Recommendation Report for Planning Permission

REF NO: LU/252/19/PL

LOCATION: Yeomans Honda
Horsham Road
Littlehampton
BN17 6DN

PROPOSAL: Removal of existing low level brick wall, existing forecourt wall to be reduced in height & graded back into the site, part of forecourt & parking areas to be overlaid with a Dense Bitumum macadam (DBM) Wearing Course, parking spaces to be delineated with white thermoplastic paint & site frontage to be secured with bollards.

Drawing
PROPOSED SITE PLAN

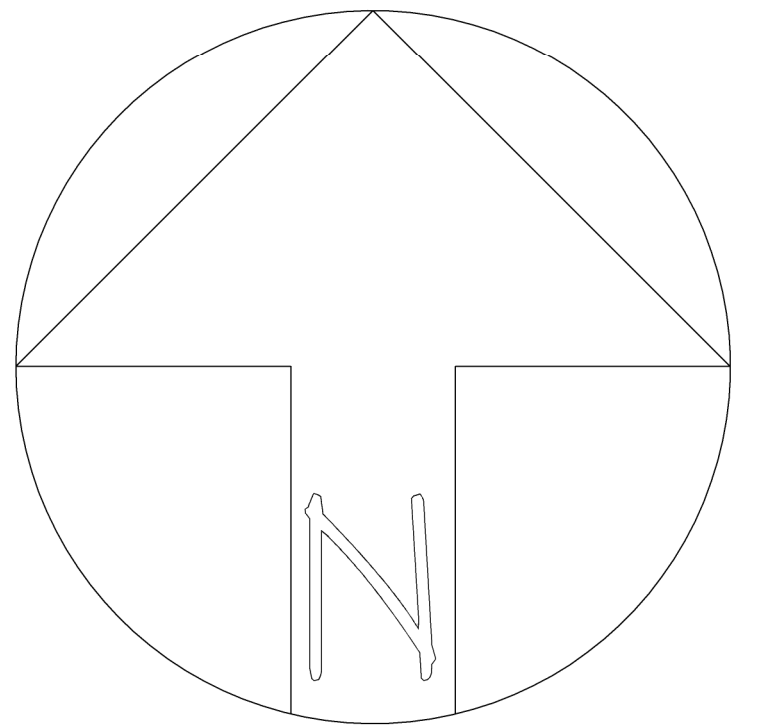
Applicant needs to clarify - The block plan demonstrates the existing slot drain at southern access aligns with the existing dwarf wall. This does not seem to be the case on the ground. This makes it difficult to establish if any of the proposed works, namely at the southern access point, will take place on the public highway

The applicant has confirmed that none of the works will take place on the public highway. Officers are satisfied.
